Single storey front extension, part two storey part single storey rear extension and alterations to fenestration. This application may affect the setting of a listed building.
Normandie Church Lane Yapton

Thank you for your internet comments made on 7th July 2019 which has been recorded as **'no objection'** with the comments as follows:

DRAWING
EXISTING & PROPOSED
FRONT & REAR ELEVATIONS

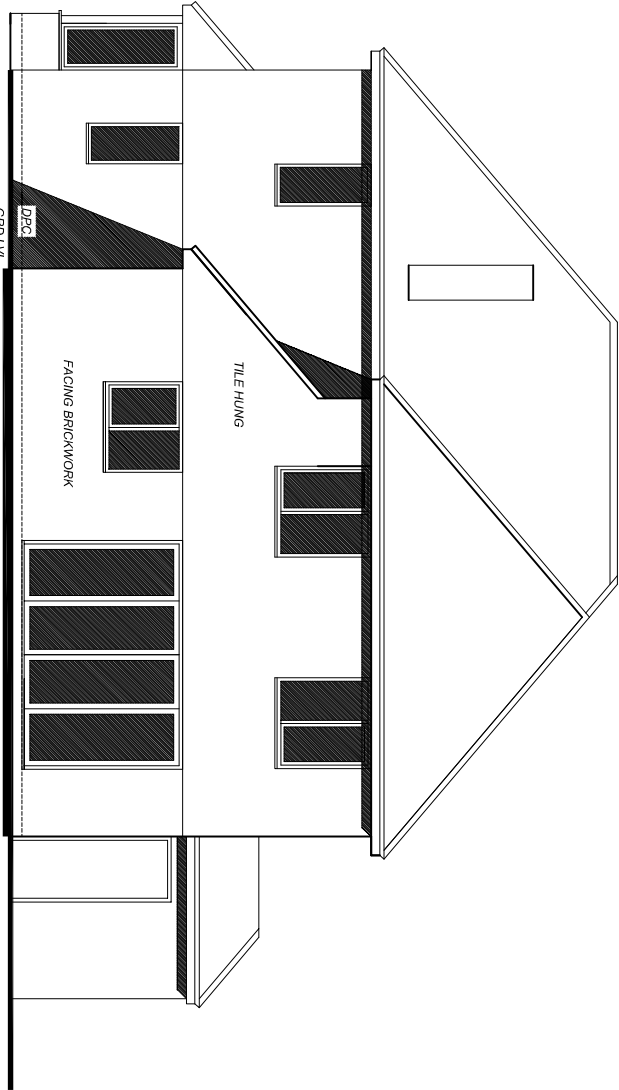
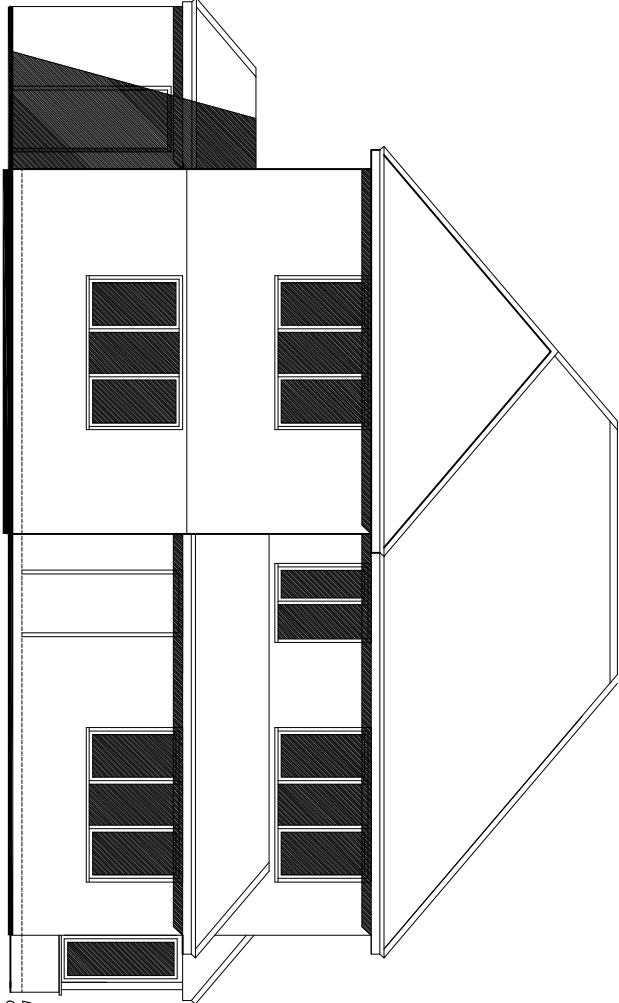
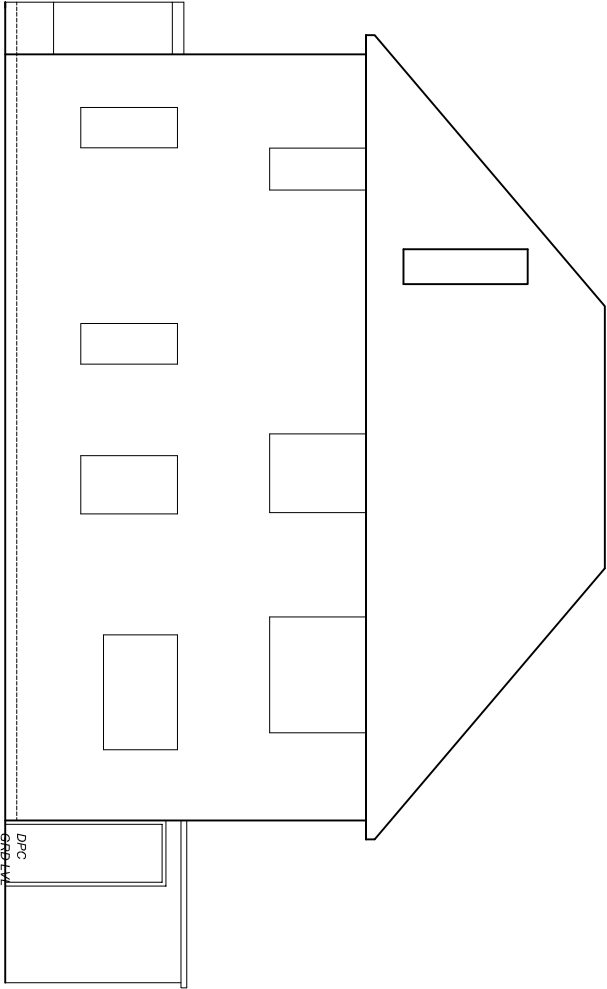
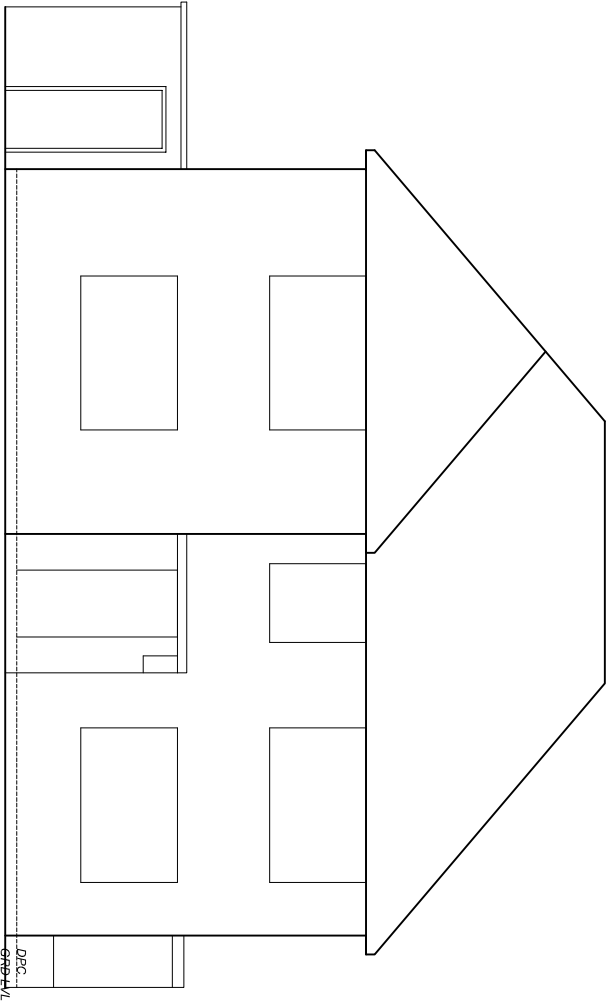
However, should planning be granted YPC would seek conditions relating to the materials used. YPC would seek that the integrity of the original architecture of the building is reflected in the choice of material ie replacement windows to be in the Crittal Window style, brickwork to match the existing etc. This is to ensure that the building does not detract from the Conservation area but enhances it.
